DECISION DELEGATED TO HEAD OF PLANNING

Application No: H14-0508-23 **Applicant:** Highgrove Homes (Spalding) Ltd.

Proposal: Residential Development of 4 Dwellings - approved under H14-1279-21. Modification of Condition 1 to allow amendments to previously approved plans

Location: Land Adj. Four Acres Beck Bank West Pinchbeck

Typical Elevation & Section of
Post & Rail Fence
Boundary Type B (Scale 1:20)

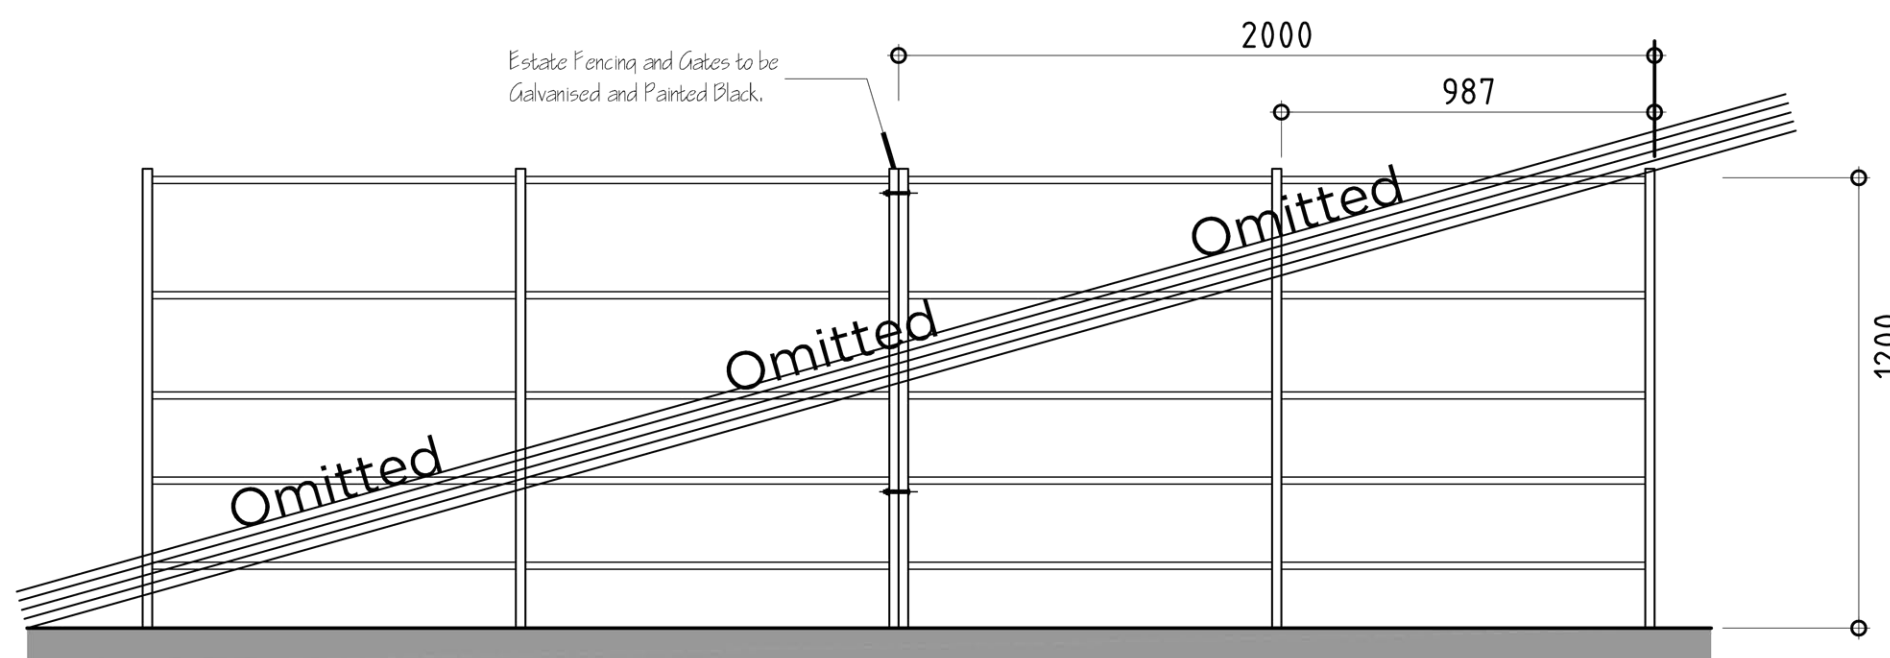
timber post and rail fencing. The fence type to be used in replacement of this will have 100mm x 75mm softwood posts with tops and 3 no. 100mm x 38mm horizontal rails scarfed both ends fixed to the face of the post.

The measurements of the fence that will be omitted are 1200mm in height and 2000mm in length, this is to be replaced by a fence that is of a similar measurements being 1200mm in height and 1830mm in length. Therefore it is considered that these measurements are acceptable as there is no significant difference between the two that could effect the area.

The proposed removal of of 'Fence Type C' to be replaced along the frontage of the site by Type B will have no detrimental impact upon the character of the area. The use of this fence type will better suite the area it is in and therefore ensure that it doesn't stand out when compared to existing fences and doesn't create any visual discrepancies as it will match what is opposite the proposal. Overall, the fence will appear well blended into the locality.
